From: Laura Gibbons <Laura.Gibbons@arun.gov.uk>
Sent: 21 September 2021 11:49
To: Planning.Responses <Planning.Responses@arun.gov.uk>
Cc: Michael Eastham <Michael.Eastham@arun.gov.uk>
Subject: RE: Planning Consultation on: A/188/21/DOC

Engineers Comments Regarding Surface Water Drainage

Registered: 3rd September 2021
Site Address: Land at Dappers Lane Angmering Littlehampton
Description of Works: Approval of details reserved by condition imposed under ref A/76/20/PL relating to Condition Nos 17 - existing & proposed ground levels, 18 - surface water drainage, 19 - maintenance & management of surface water drainage, 21 - discharge flows to watercourses and 22 - foul drainage system

Drawing Status	CONSTRUCTION
Scale	A1
Date	October 2020
File	20079/dwgs/civils/current
Drawn	LJ
Checked	
Drawing	
20079 - 326 E

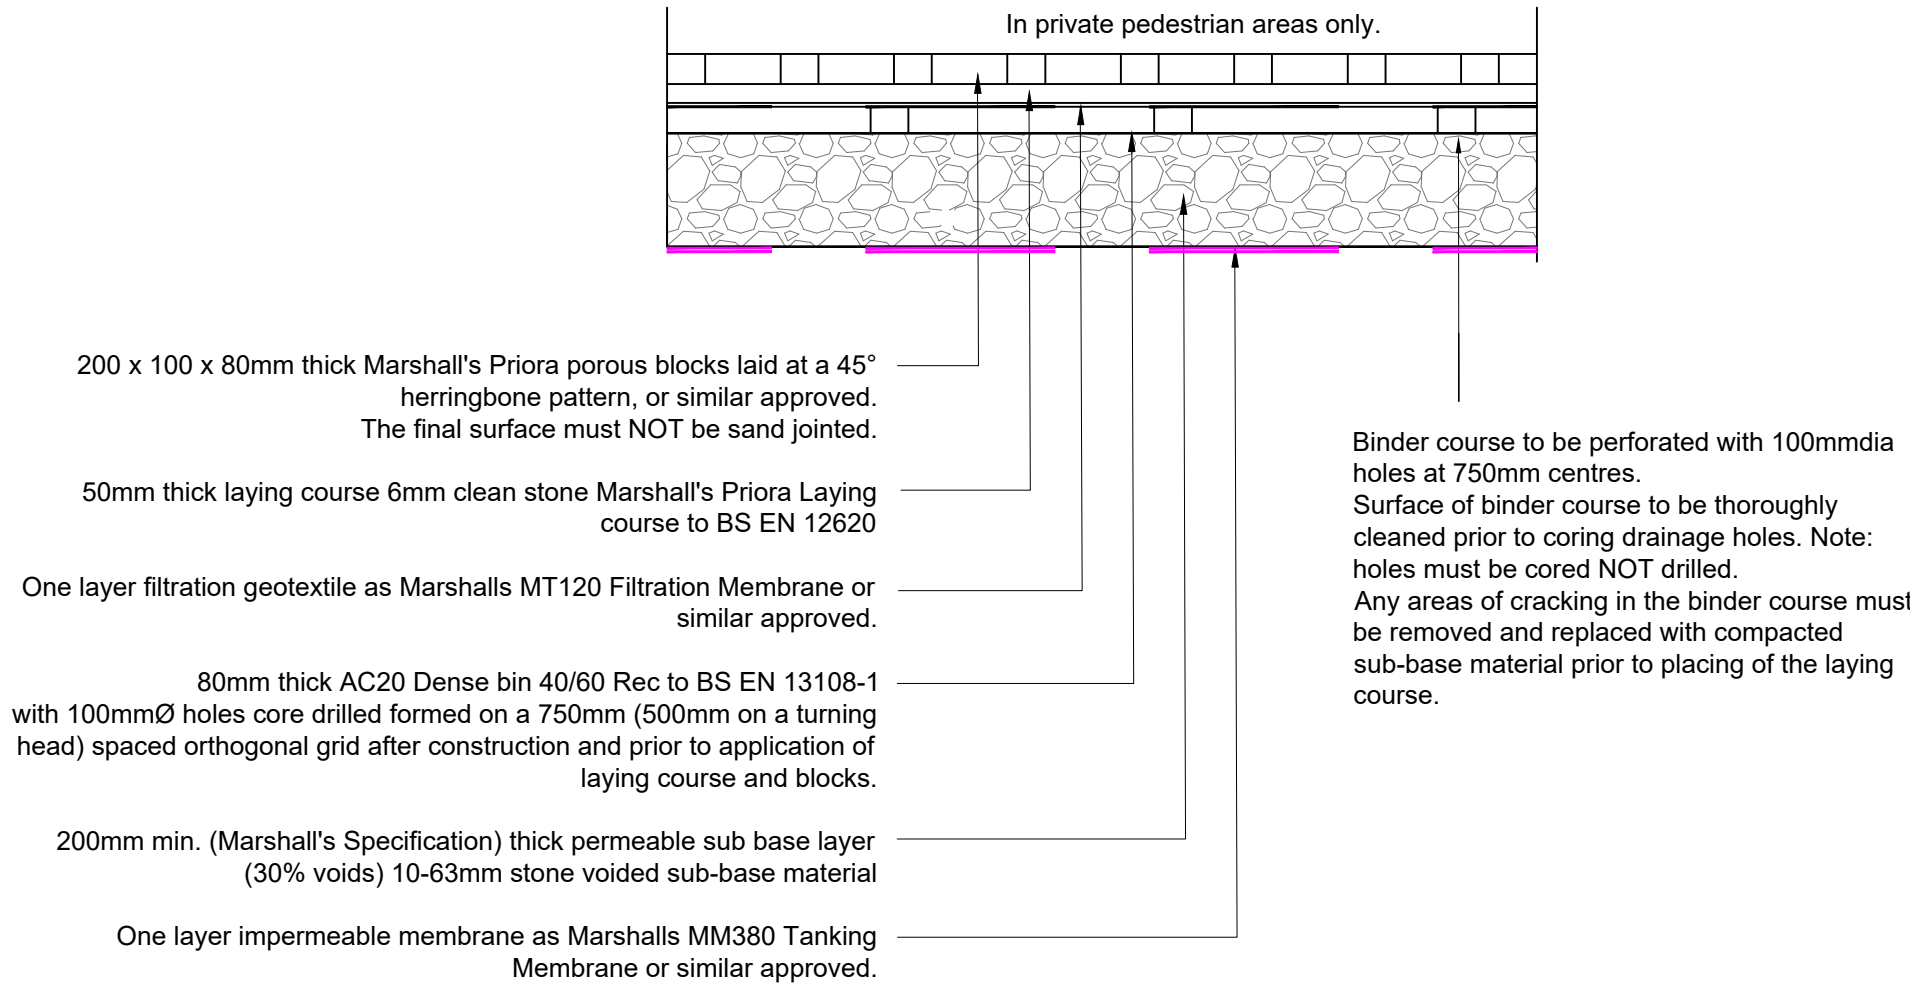
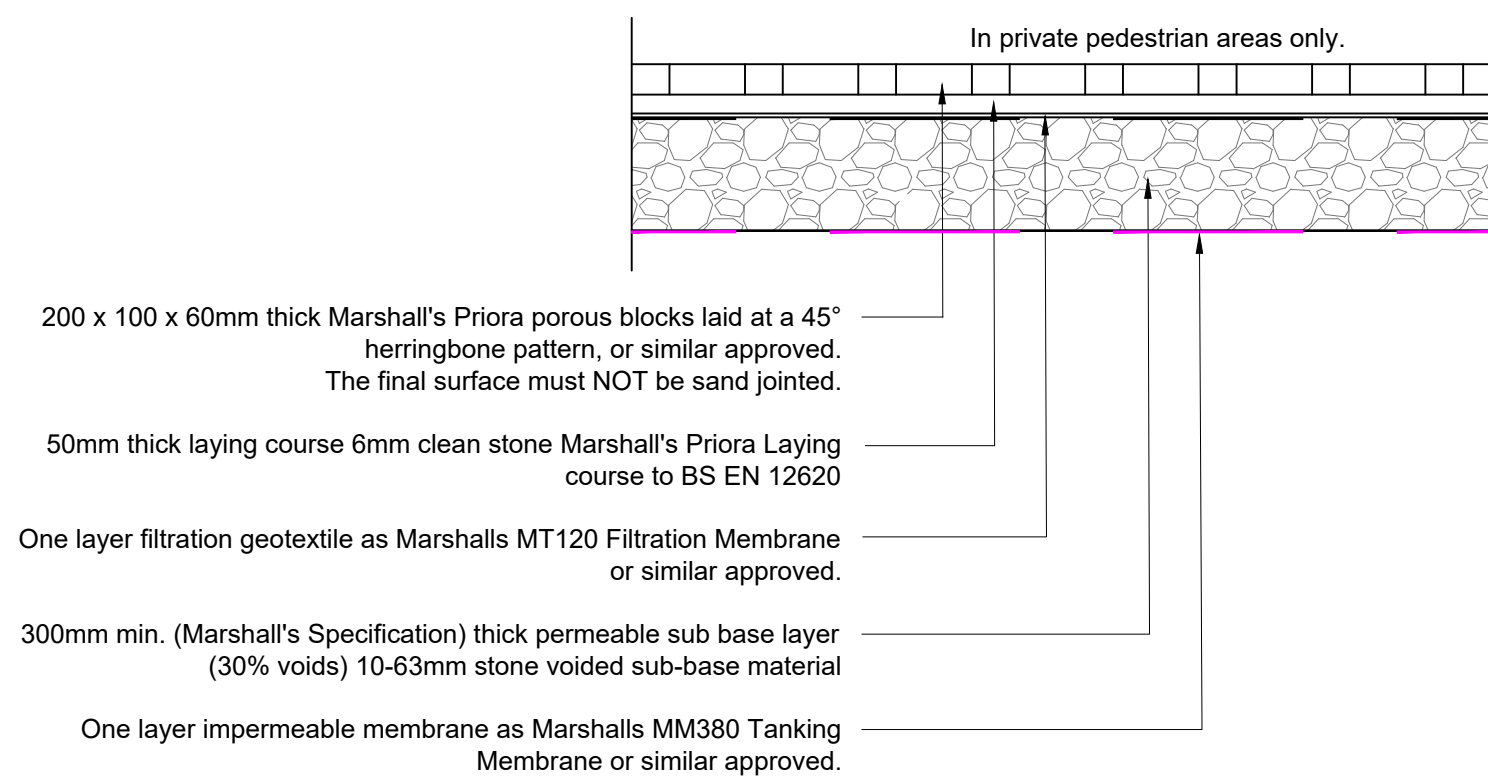
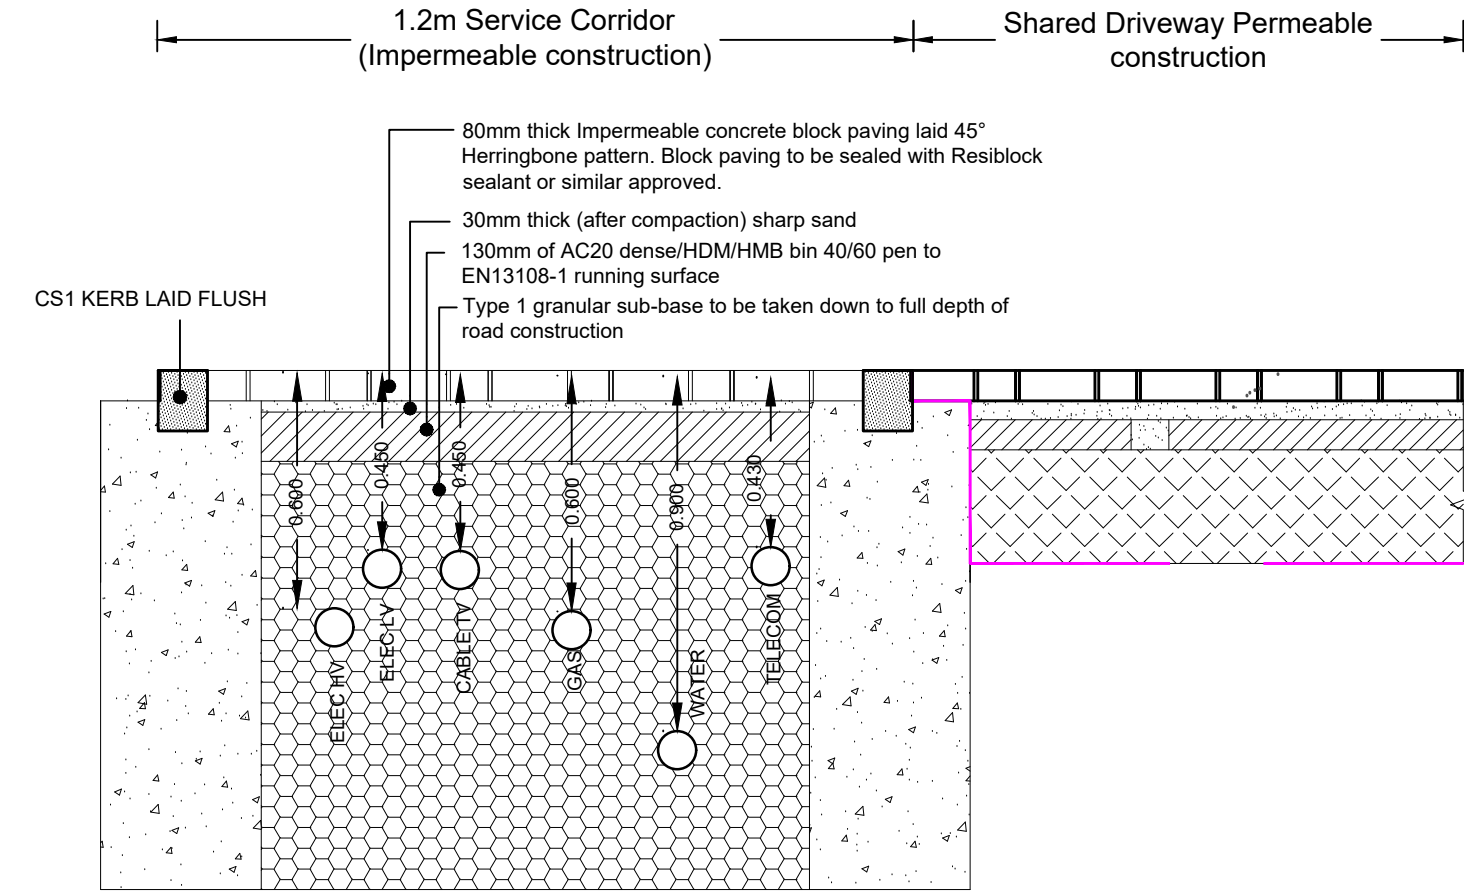
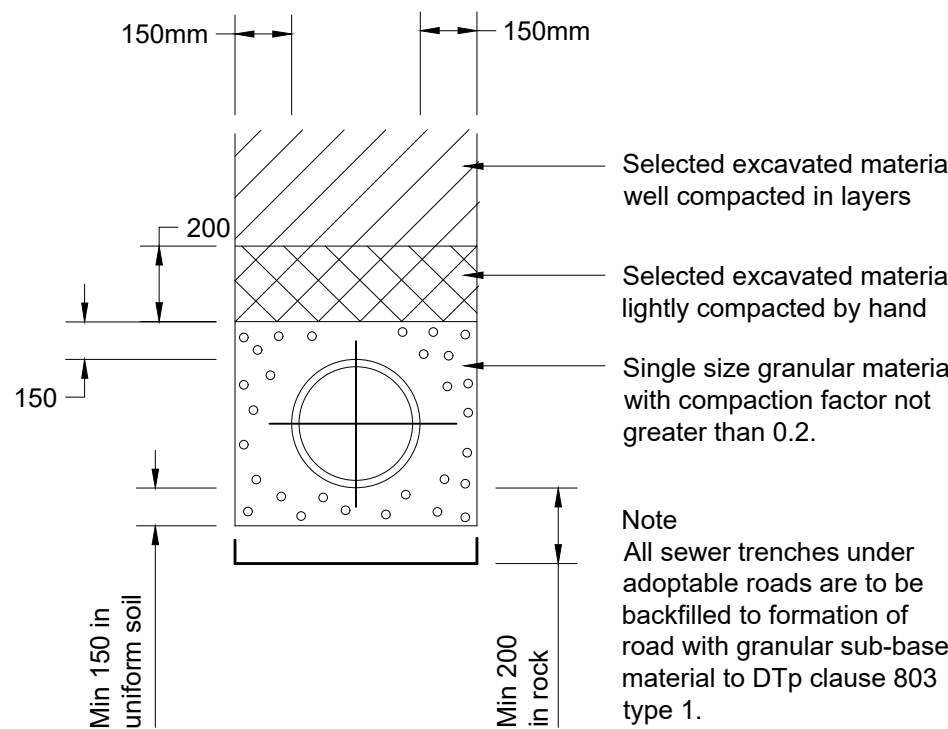
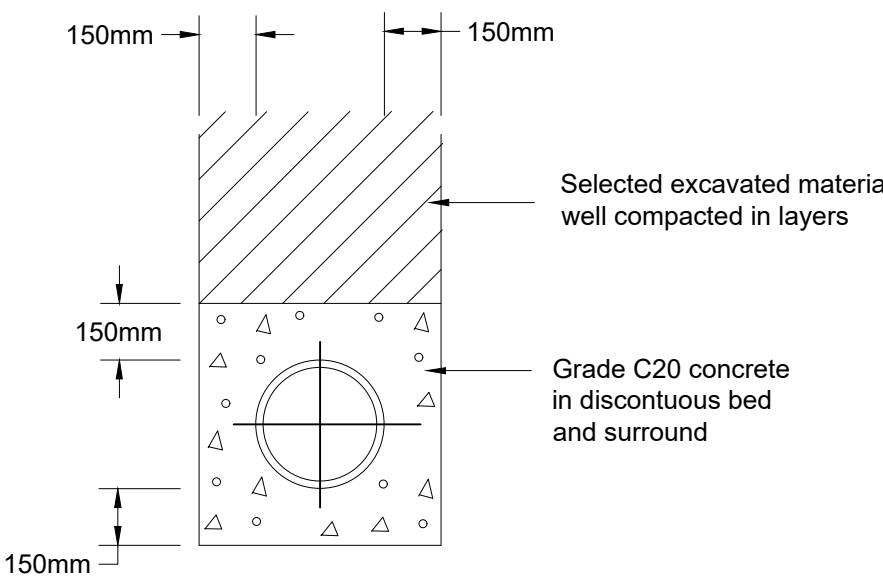
15. *Please provide full construction detail drawings. Please provide construction detail drawings of catchpits, ACO drains, permeable paved roads, etc.*

Please detail what bed and surround requirements are for pipes outside of adoptable highways.

BGC 30/08/21 – Full set of Construction Details provided within latest submission including ACO drains and permeable paved roads. Please refer to drawings; 20079/311, 20079/315, 20079/316, 20079/320, 20079/321, 20079/322, 20079/326, 20079/327, 20079/330 & 20079/331.

REF 20079 - CC12

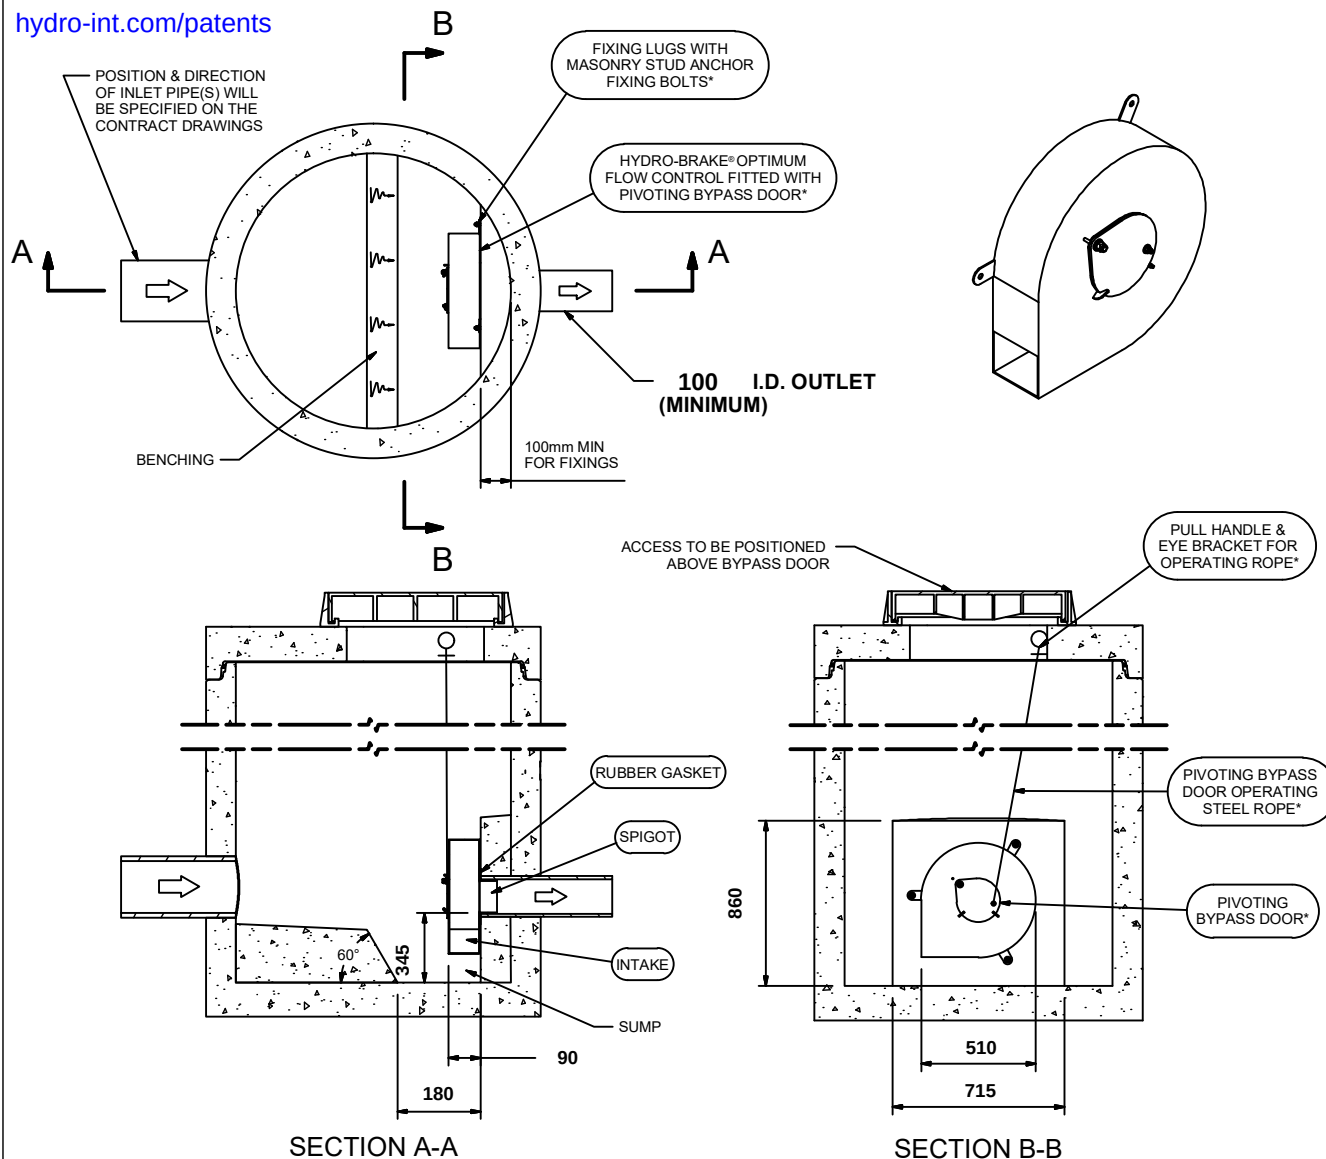
4. Please provide cover levels on plans. Cover levels of attenuation tanks should be provided on layout plan too. CL of CC12 is incorrectly detailed on plan. Please also see comment 6 below. BGC 30/08/21 – Cover levels of attenuation tanks added to plan & CC12 cover level corrected, see drawings; 20079/1005104 & 20079/116-118. See below comments.

Overflow levels at CC12 and CC28 appear to be below 100 year plus 40% cc water level.
